# Construction Drawings\_V2\_Comments.pdf Markup Summary

CE1.1

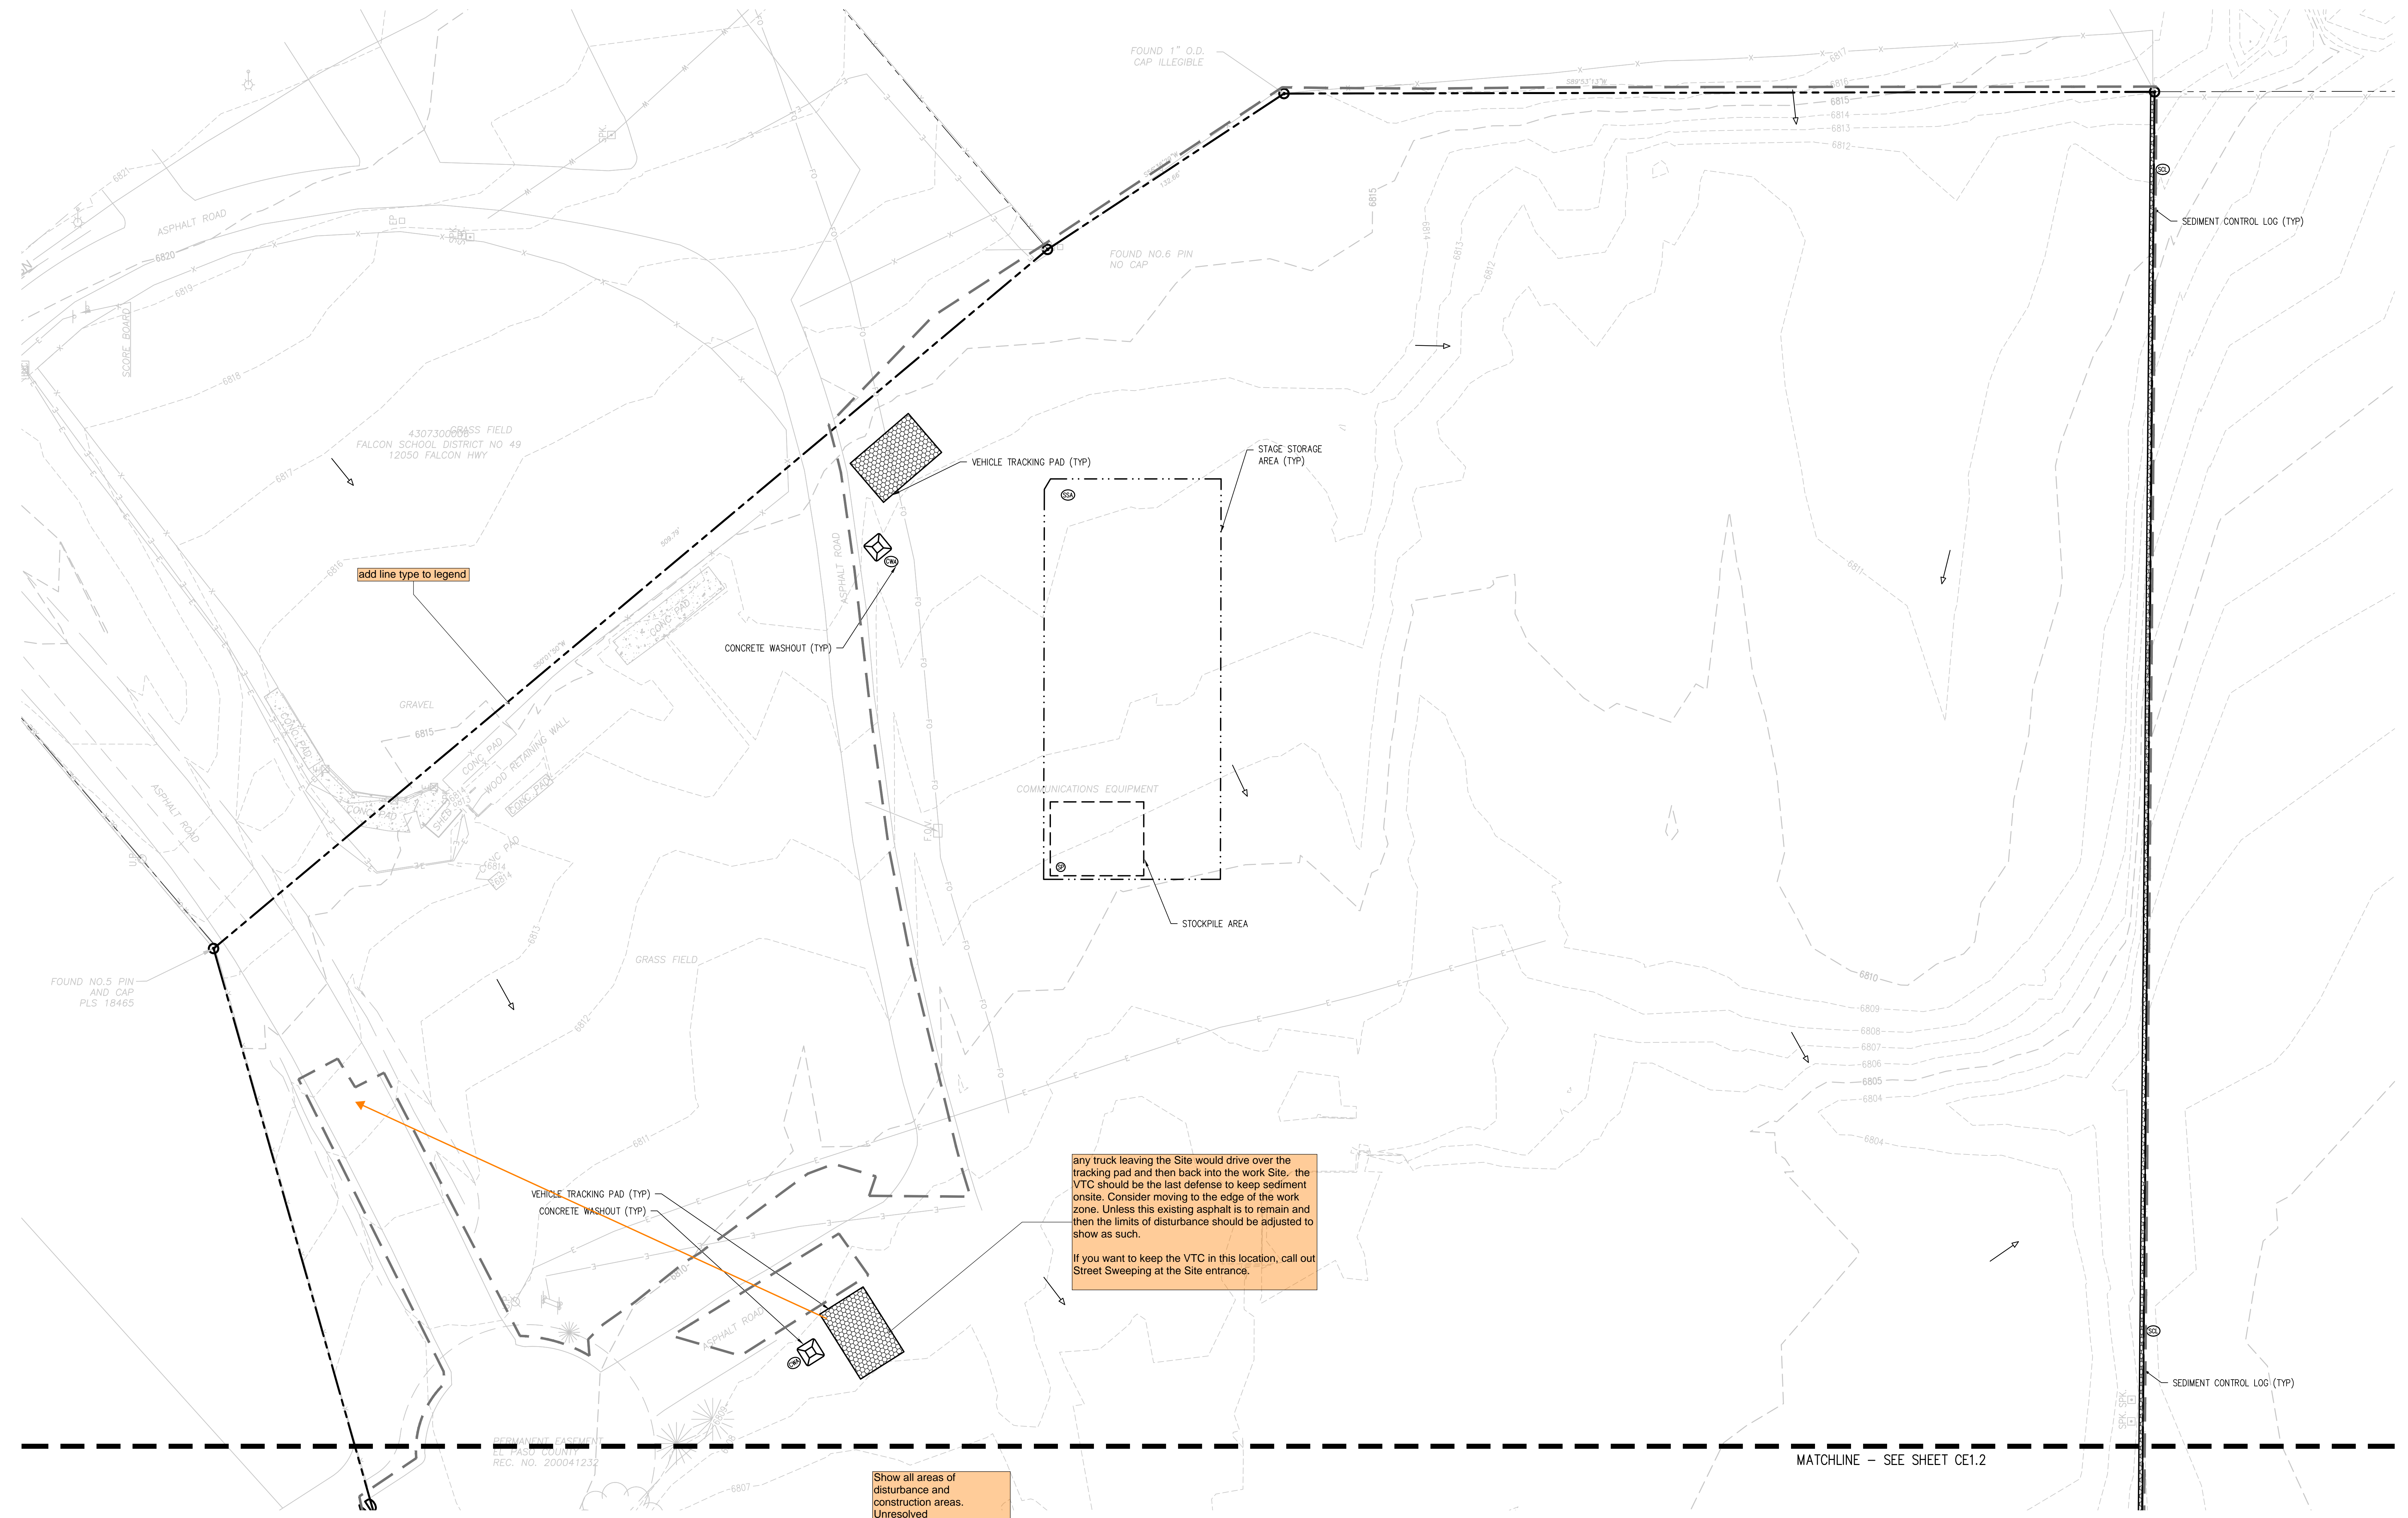
any truck leaving the Site would drive over the tracking pad and then back into the work Site. the VTC should be the last defense to keep sediment onsite. Consider moving to the edge of the work zone. Unless this existing asphalt is to remain and then the limits of disturbance should be adjusted to show as such.

If you want to keep the VTC in this location, call out Street Sweeping at the Site entrance.

Show all areas of disturbance and construction areas.  
 Unresolved

CE1.2

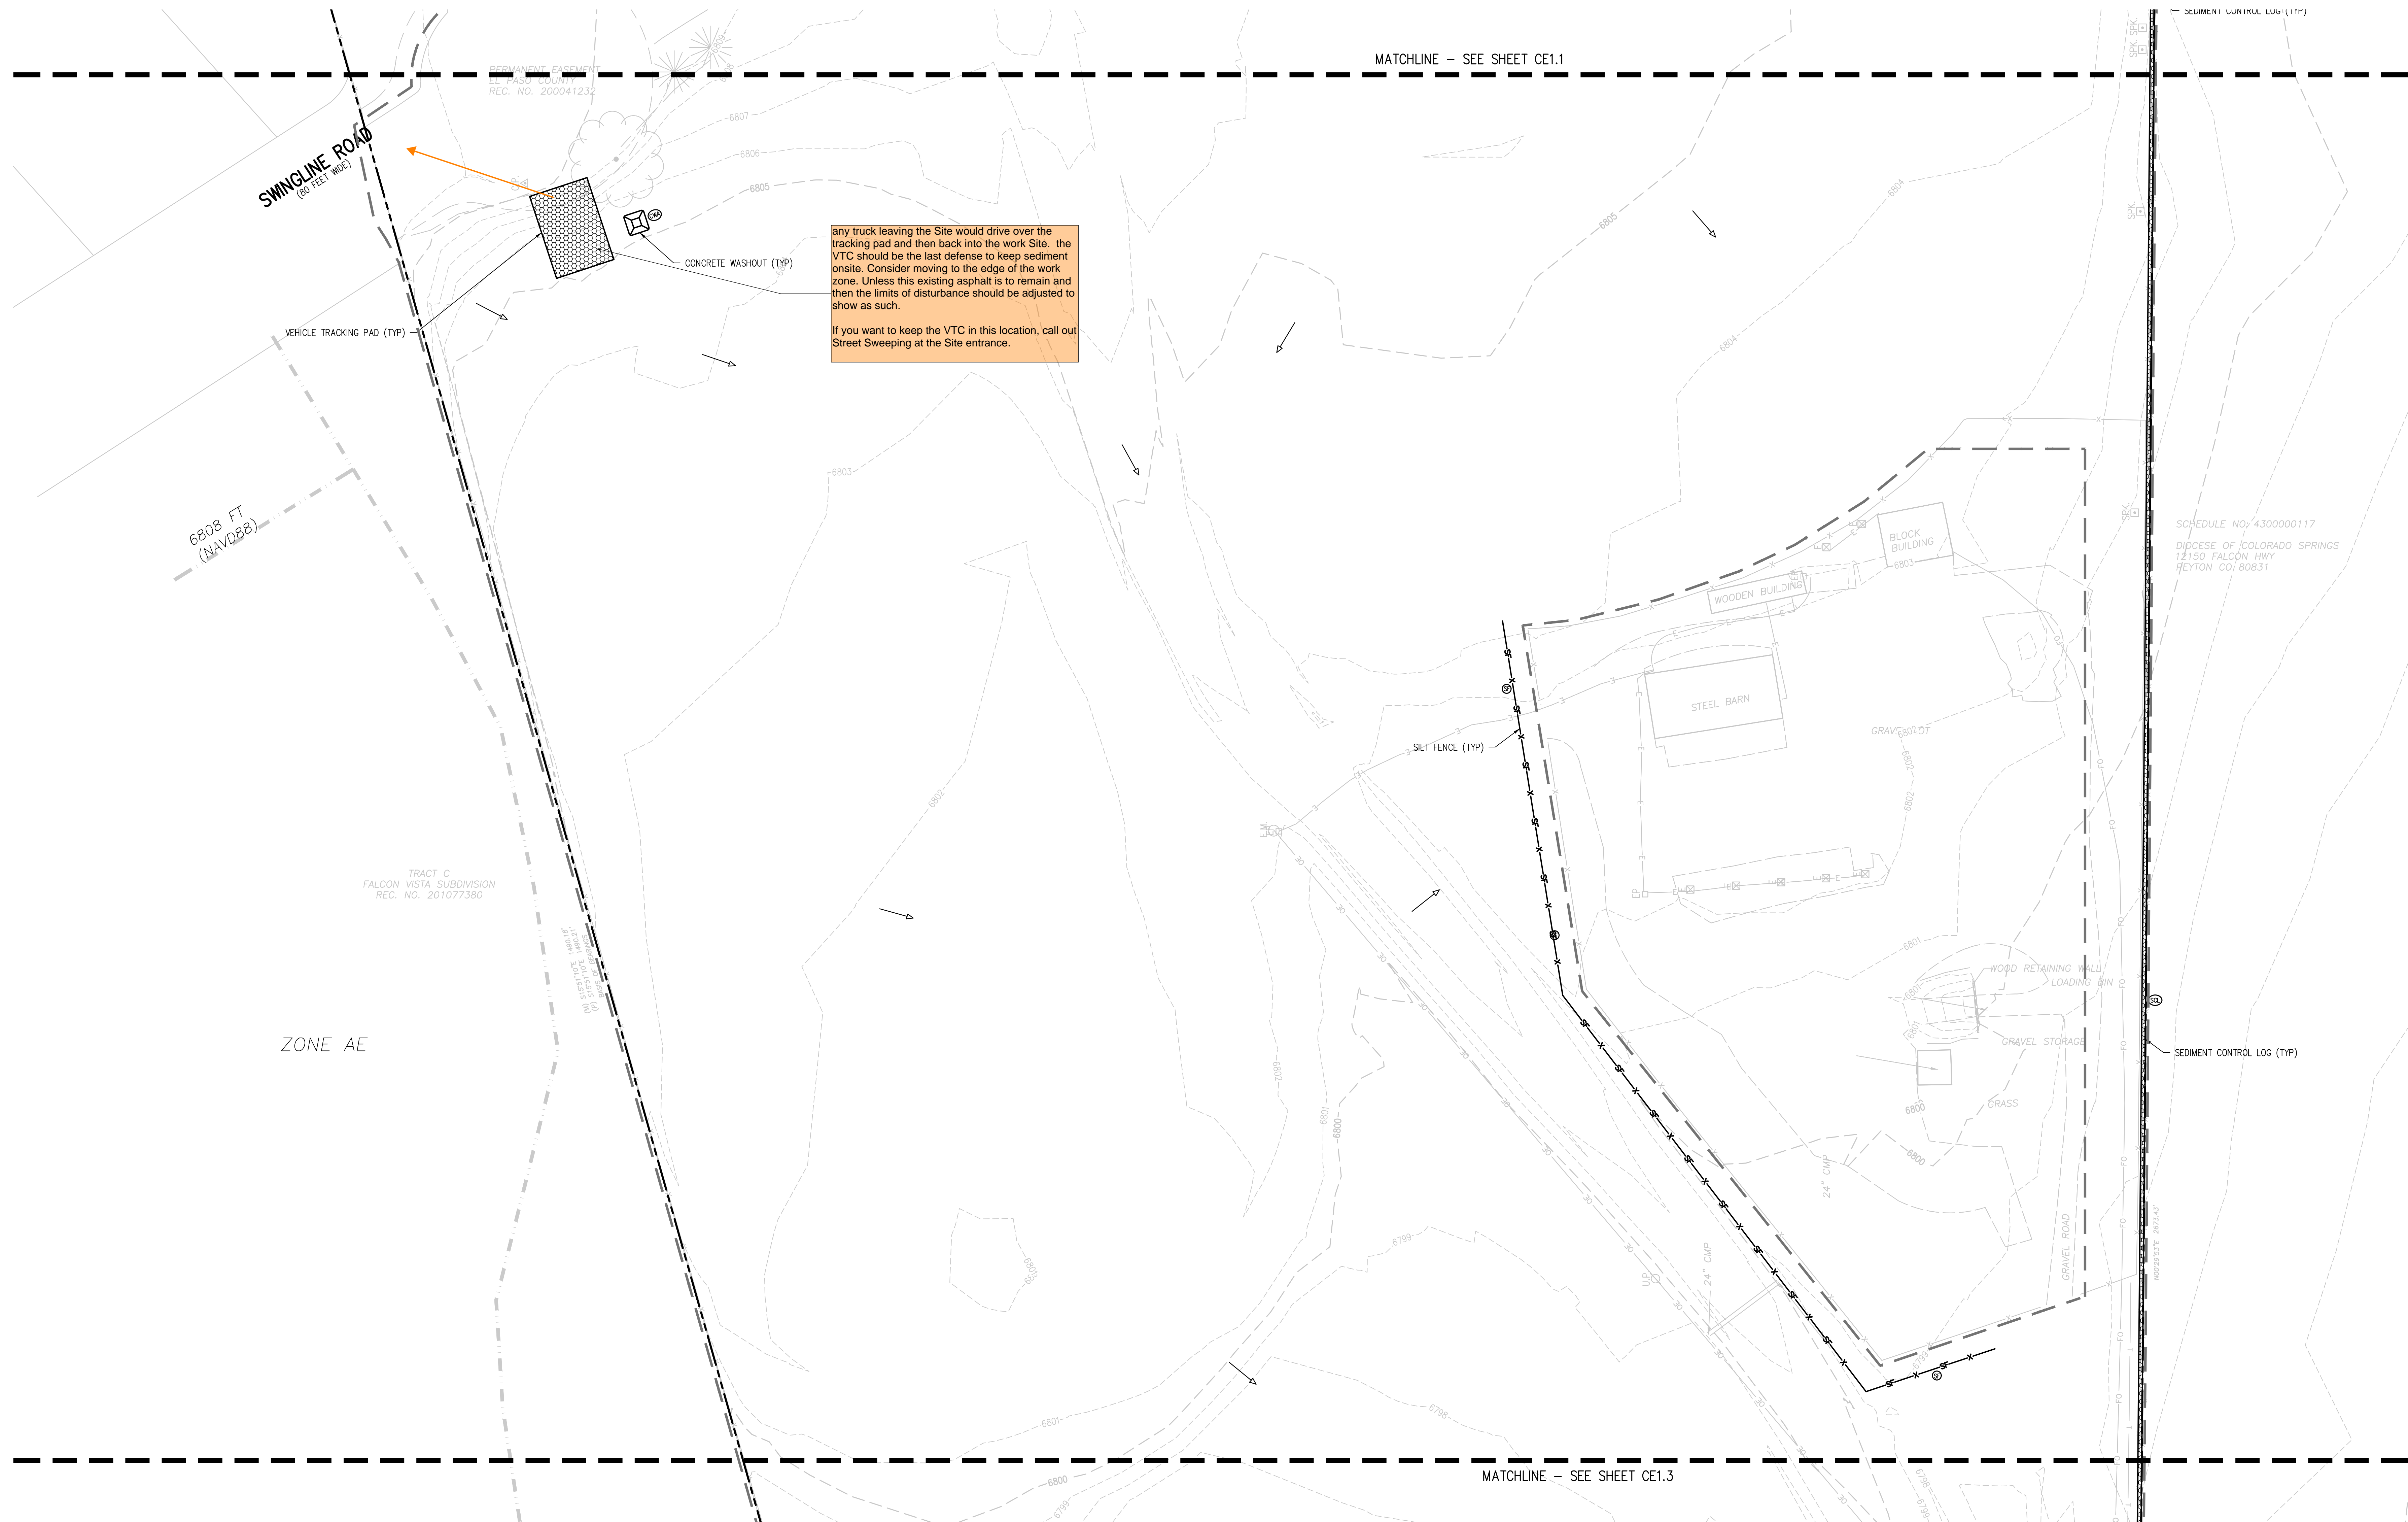
any truck leaving the Site would drive over the tracking pad and then back into the work Site. the VTC should be the last defense to keep sediment onsite. Consider moving to the edge of the work zone. Unless this existing asphalt is to remain and then the limits of disturbance should be adjusted to show as such.

If you want to keep the VTC in this location, call out Street Sweeping at the Site entrance.

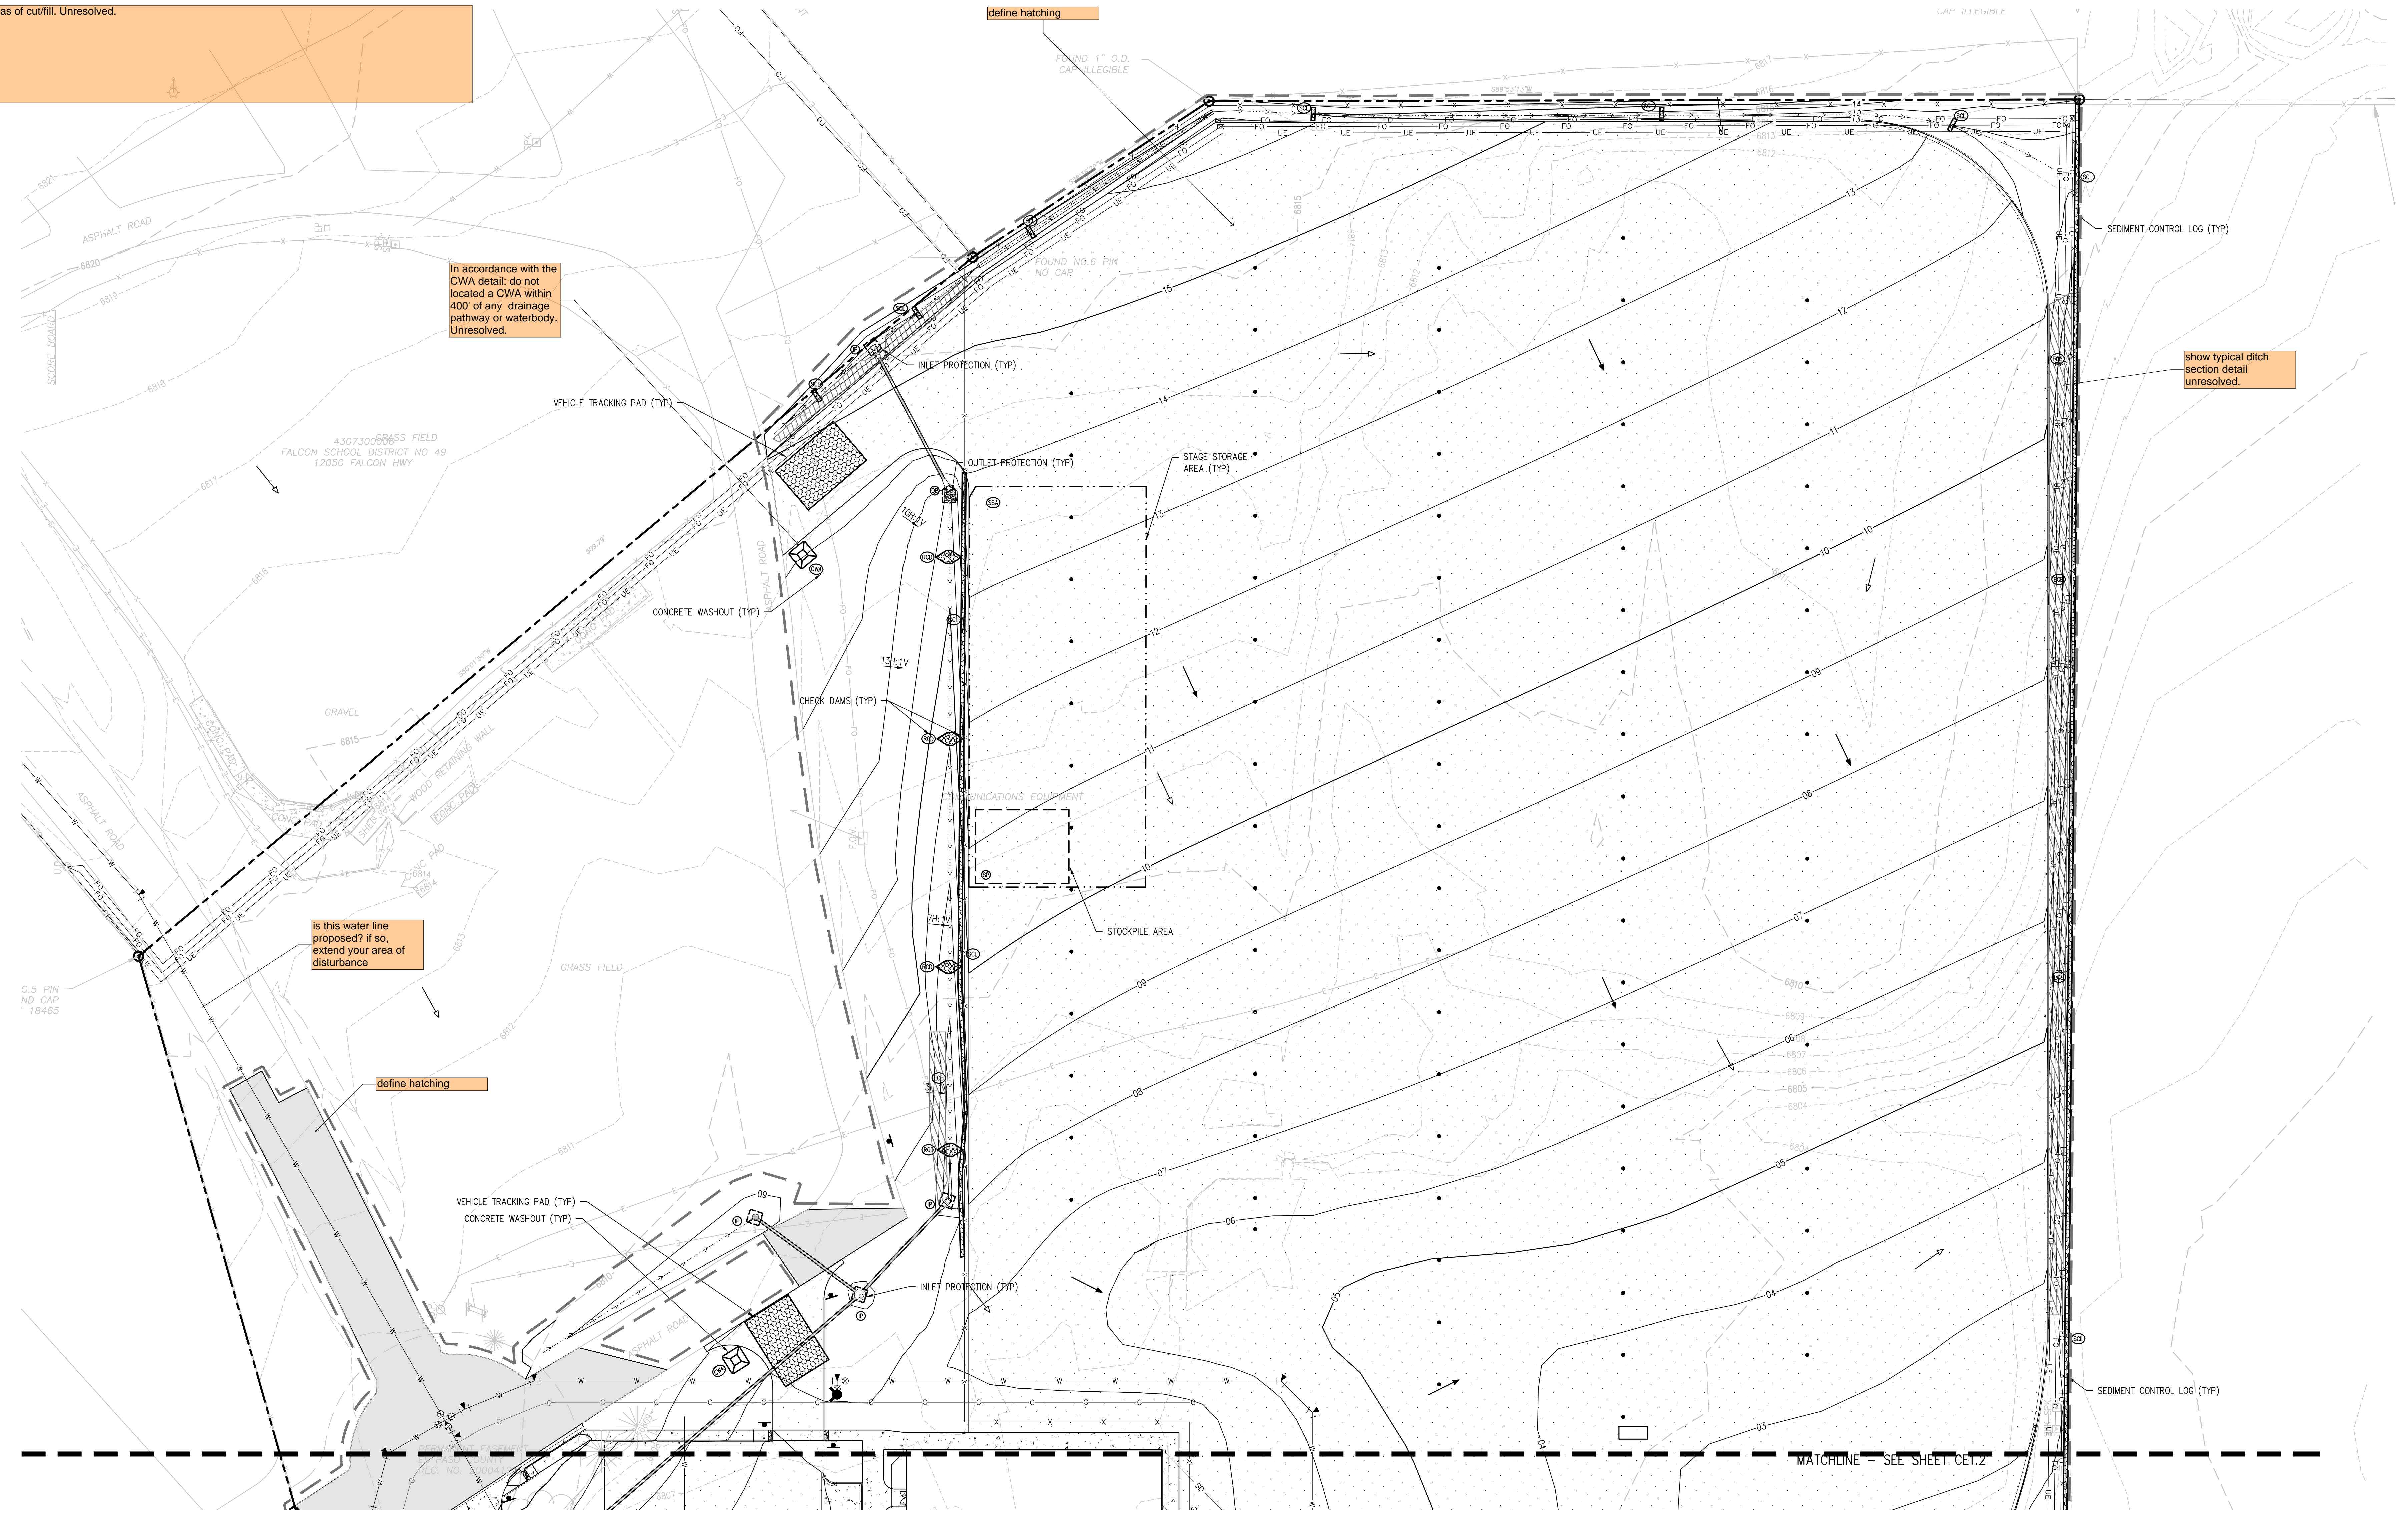
show all areas of cut/fill. Unresolved.

is this water line proposed? if so, extend your area of disturbance

show typical ditch section detail unresolved.

In accordance with the CWA detail: do not located a CWA within 400' of any drainage pathway or waterbody.  
 Unresolved.
